From: Barry Stowe <barrys@opechee.com>
To: 'Jean Fraser' <JF@portlandmaine.gov>
CC: Steve Long <stevel@opechee.com>, Jason Blais <jasonb@opechee.com>
Date: 1/15/2013 2:33 PM
Subject: RE: Site Plan (CO4) RE: JB Brown
Attachments: Revised Project Data Marriott Portland 01-15-13.pdf; Lighting Specs Marriott Portland 01-15-13.pdf; Highland Stone Retaining Wall Marriott Portland 01-15-13.pdf; C10 Construction Details Marriott Portland 01-15-13.pdf; C00 Cover Sheet Marriott Portland 01-15-13.pdf; C02 Existing Conditions Marriott Portland 01-15-13.pdf; C03 Demolition Plan Marriott Portland 01-15-13.pdf; C04 Site Plan Marriott Portland 01-15-13.pdf; C09 Photometrics Plan Marriott Portland 01-15-13.pdf; C08 Landscaping Plan Marriott Portland 01-15-13.pdf

Subject: Site Plan (CO4) RE: JB Brown

DATE: 10-22-12
SCALE: 1"=20'
DRAWN BY: BJB
C03
SHEET: 3 OF 14

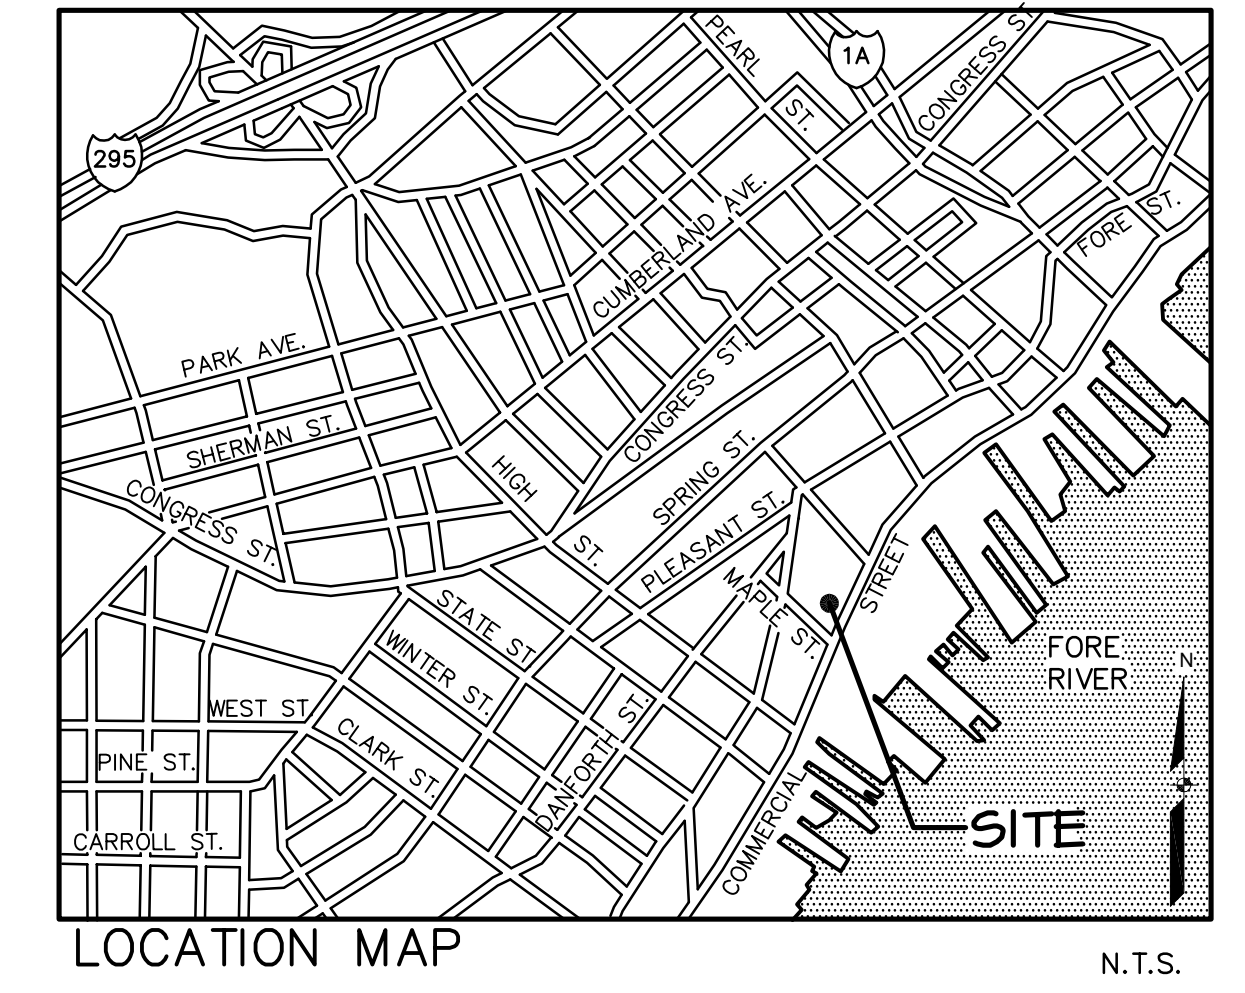
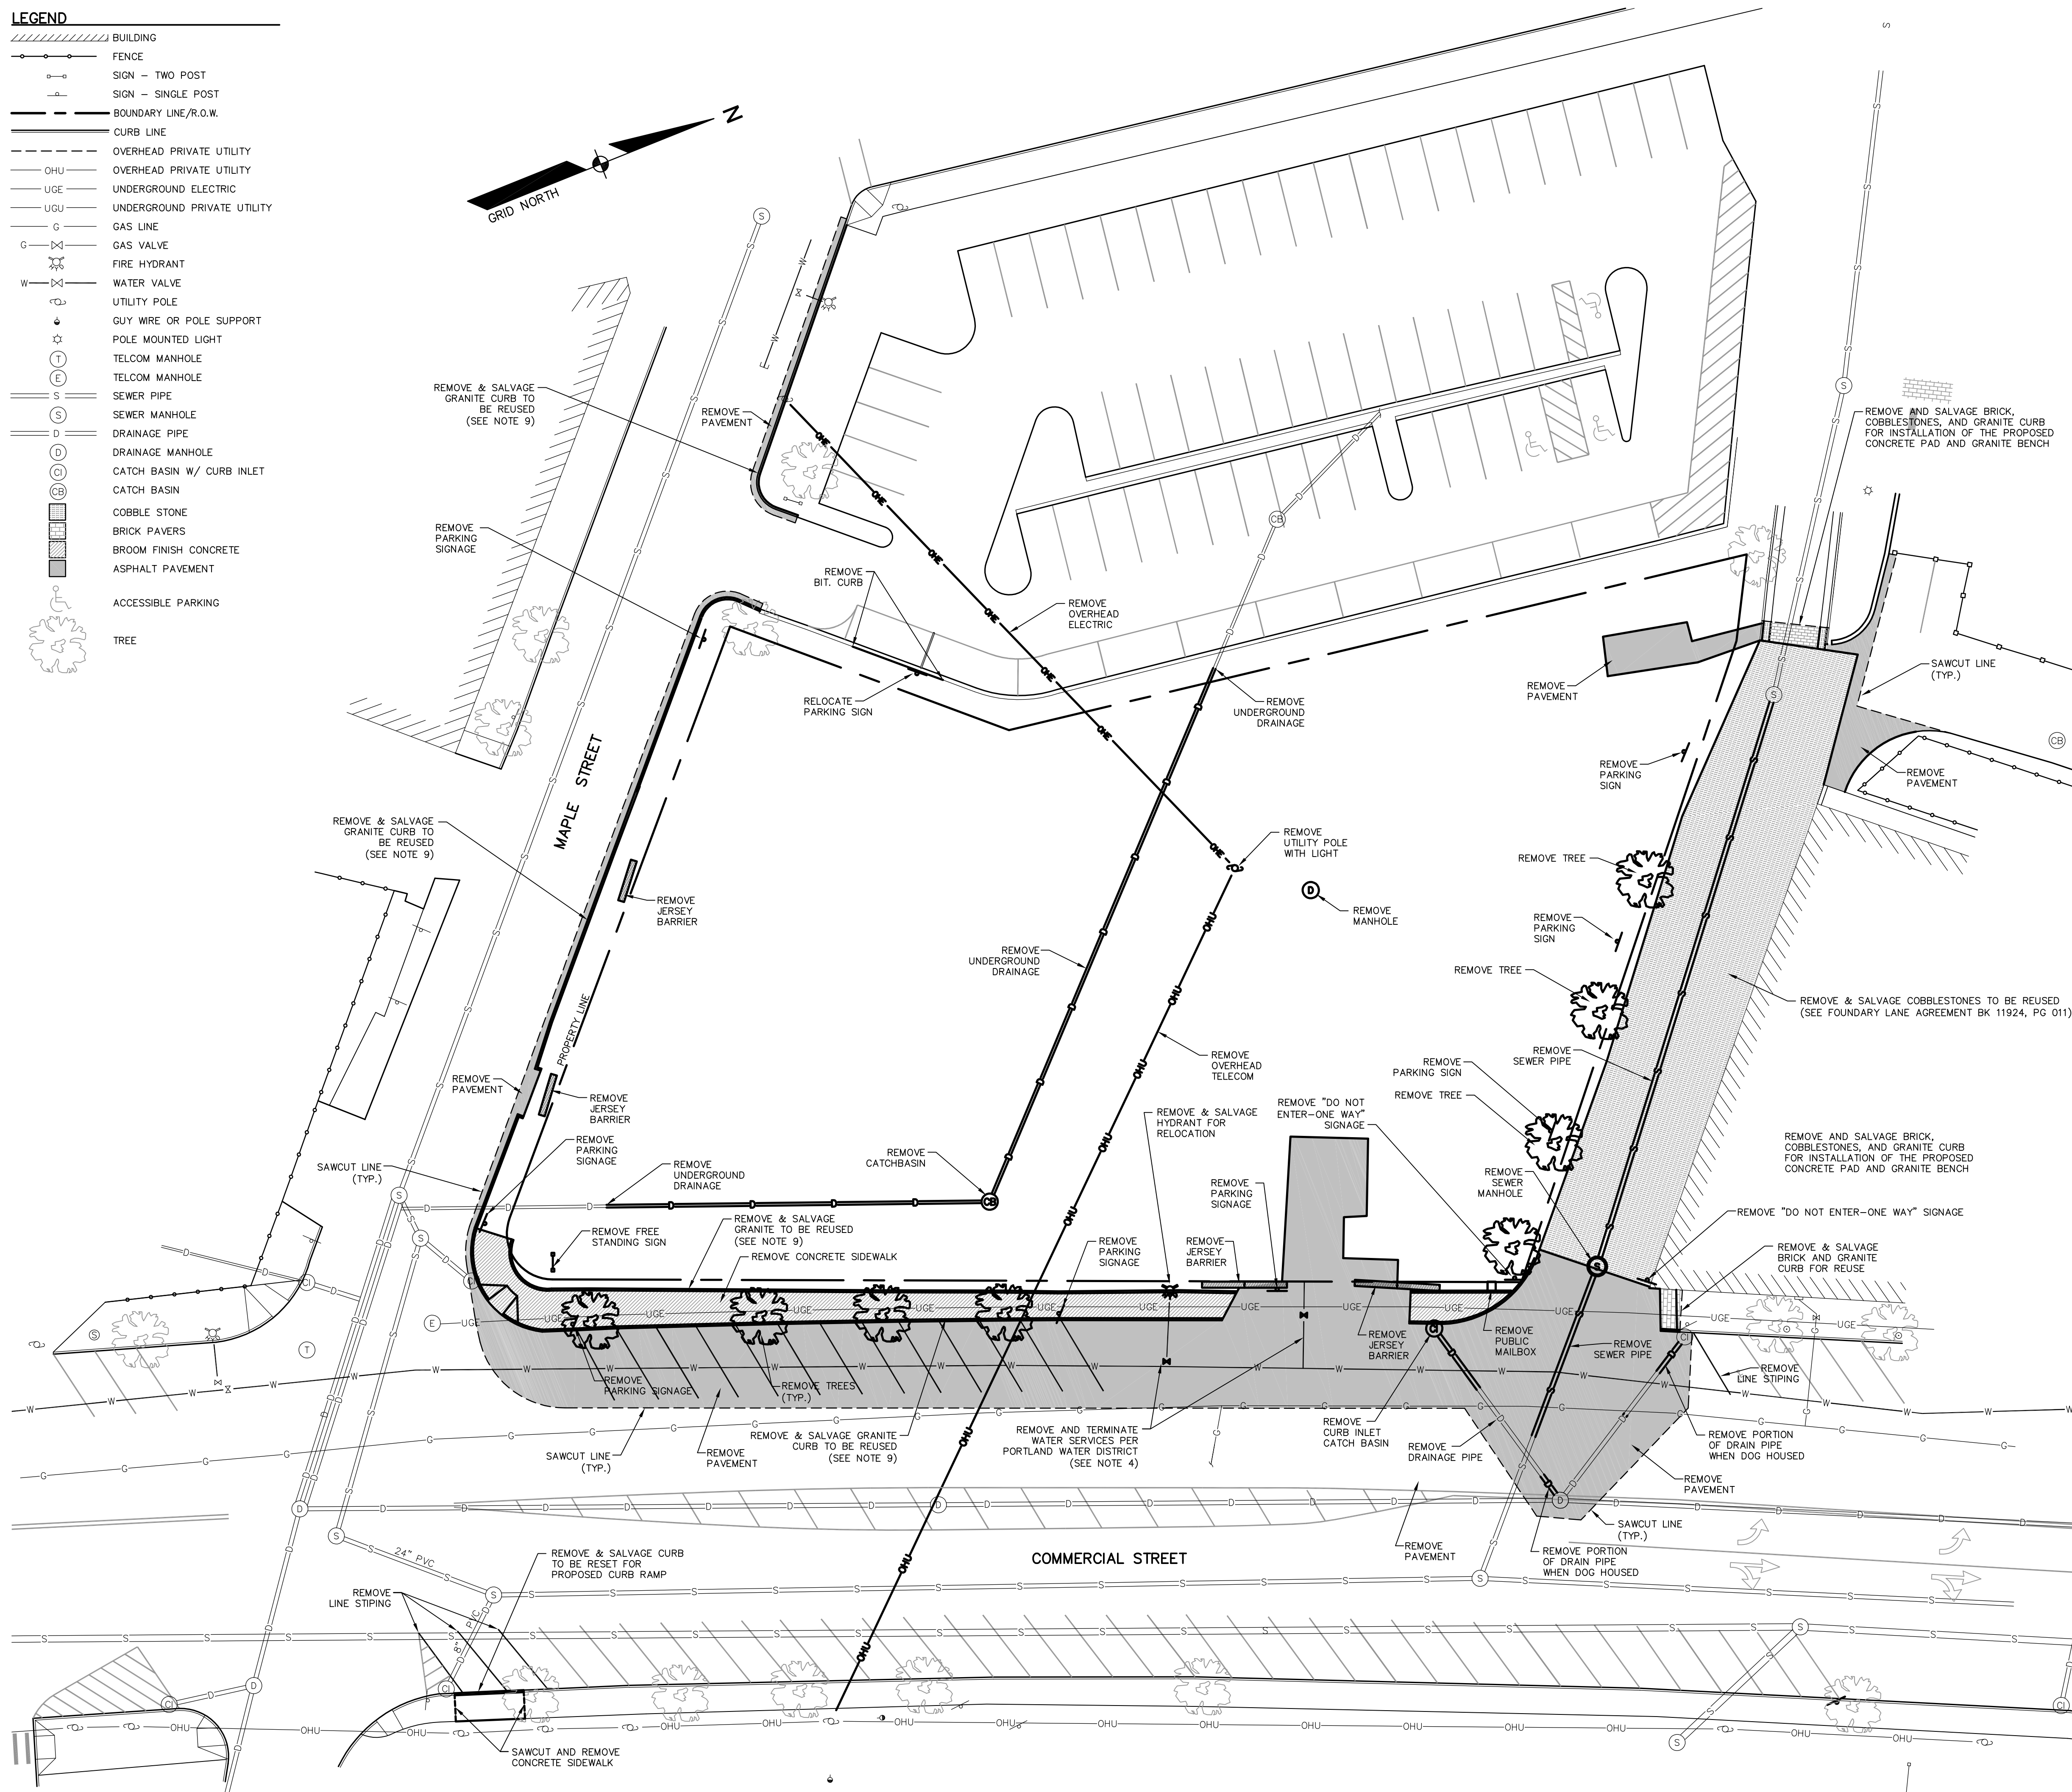
- C00 Cover Sheet
 - Changed revisions to be current
- C02 Existing Conditions
 - Revised a couple typo's on elevations
- C03 Demolition Plan
 - Added the removal of a portion of existing drainage pipe to accommodate new manhole (trench drain revision)

C08
 SHEET: 8 OF 14

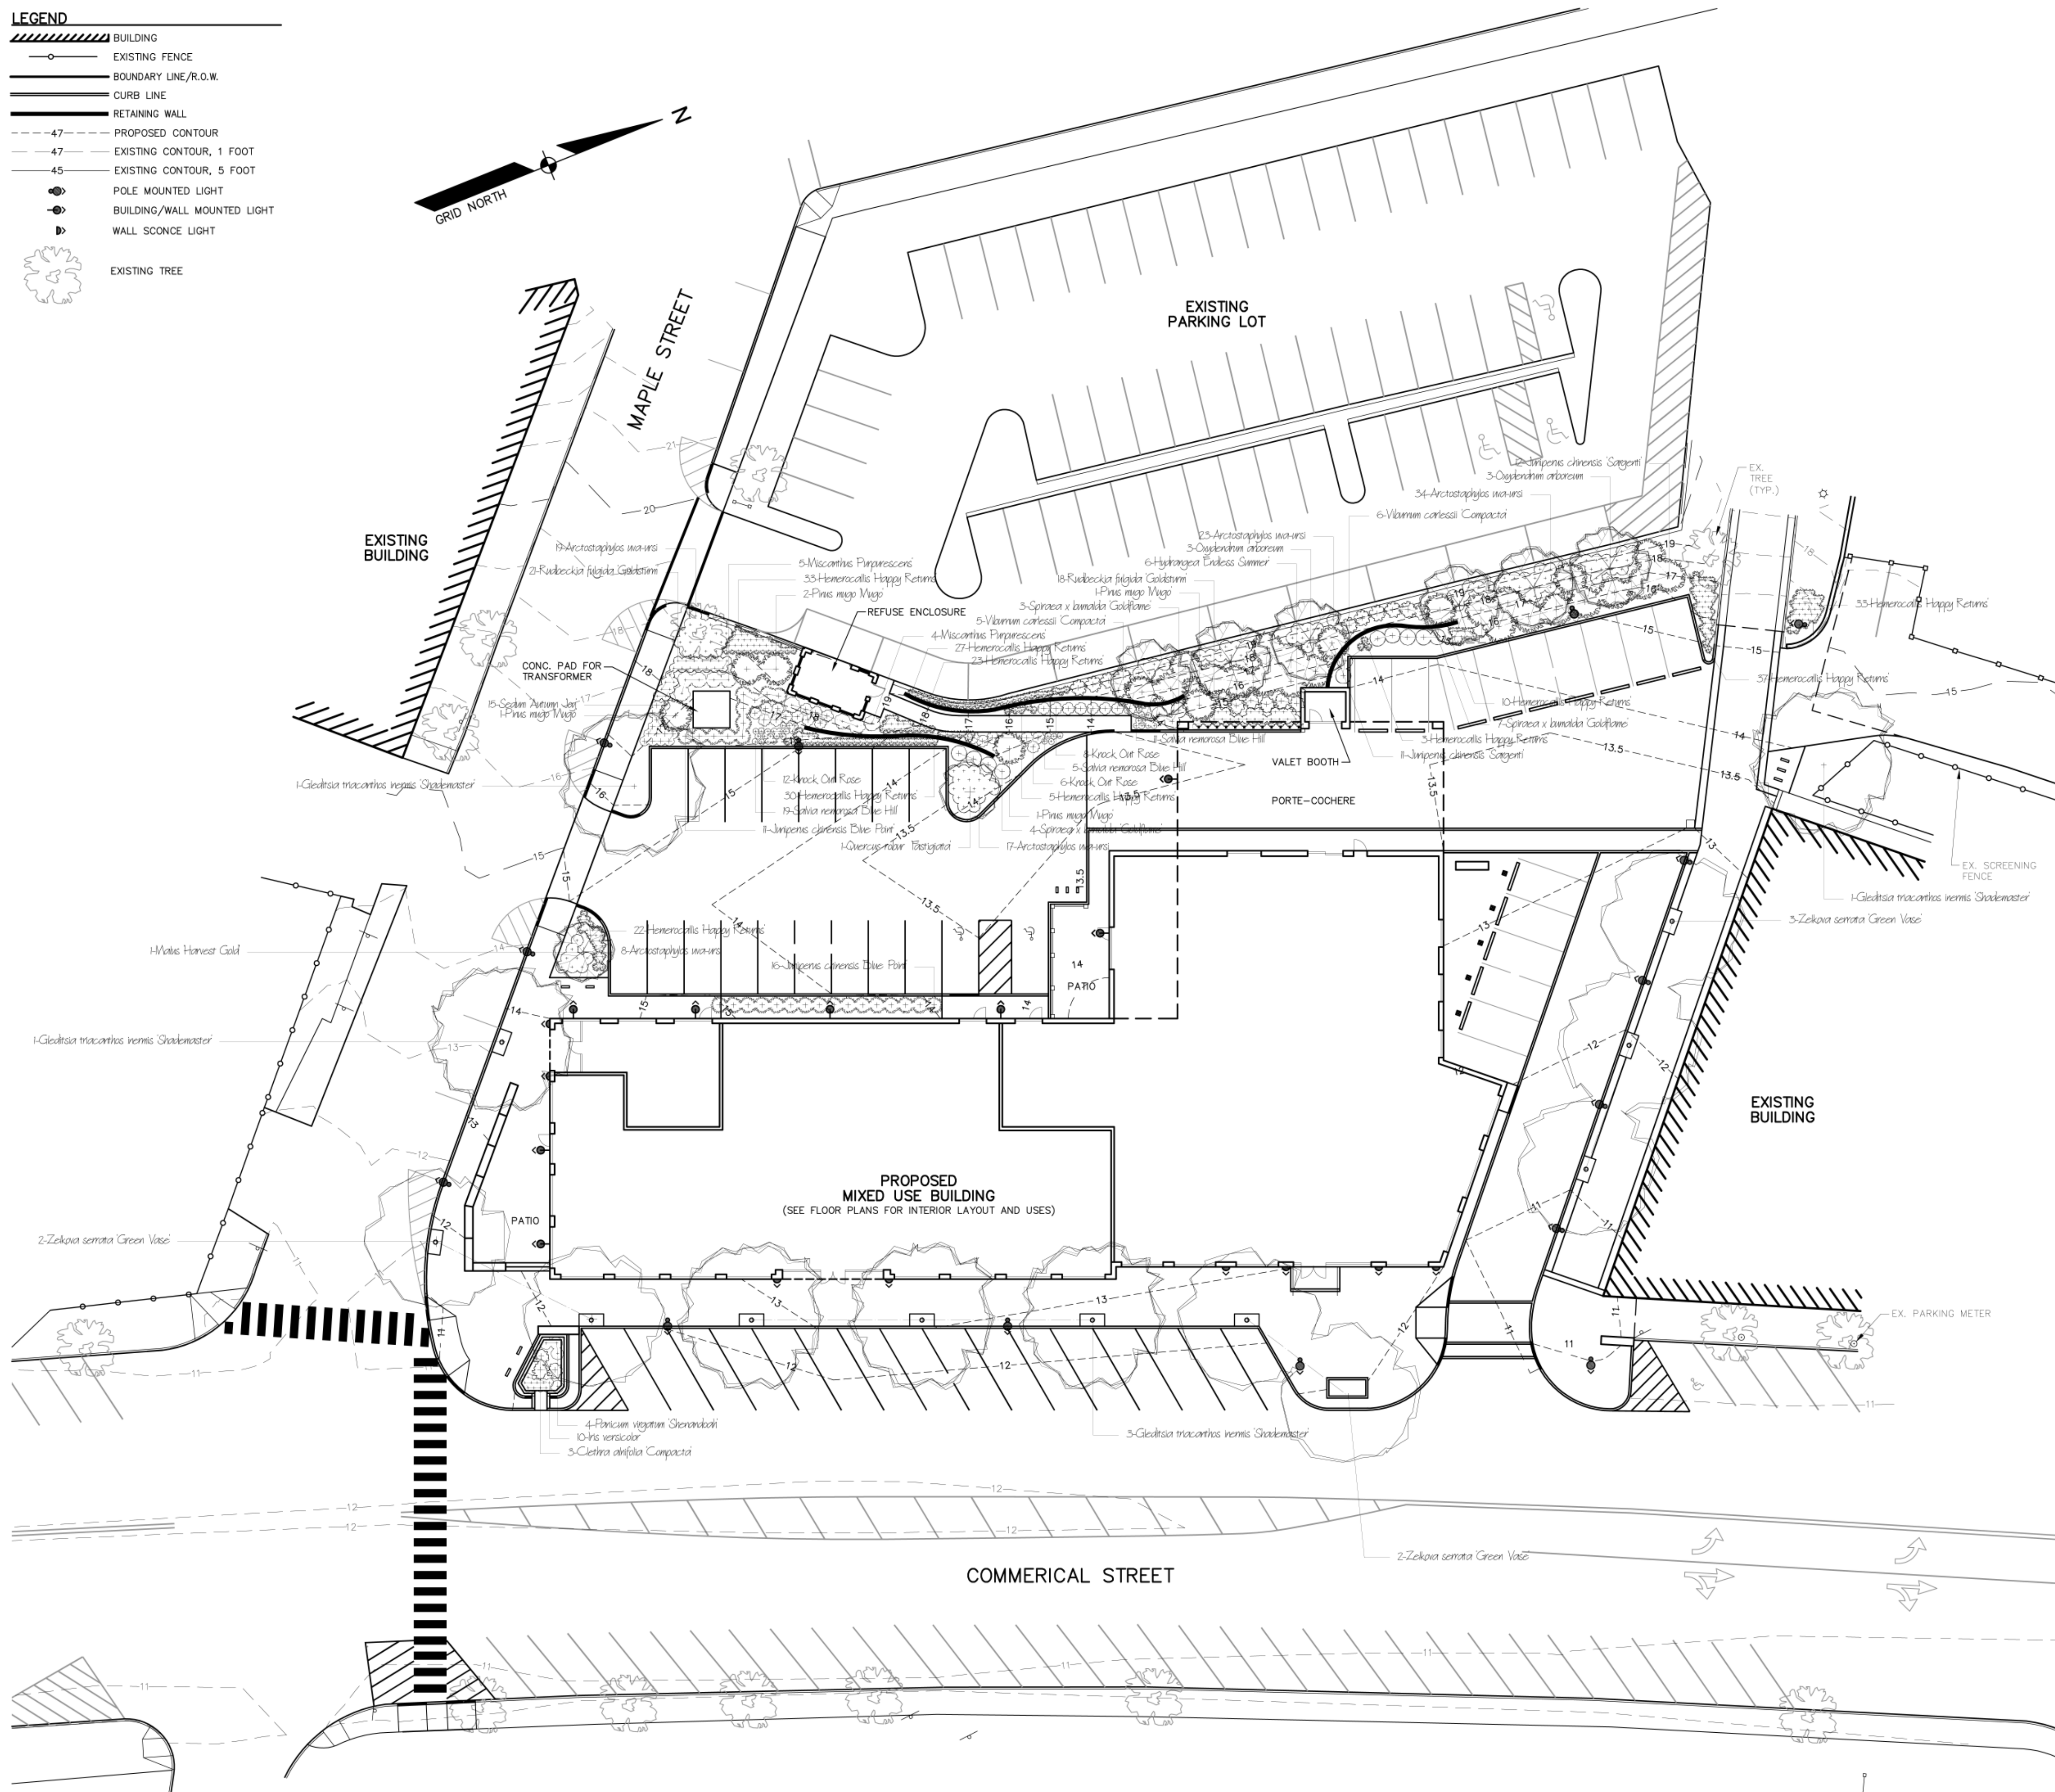
- Made the site plan layout current per revisions (no landscape revisions)
- C09 Photometric Plan
 - Added lighting schedule
 - Revised Note #through #5
 - Removed City street lights from calculations
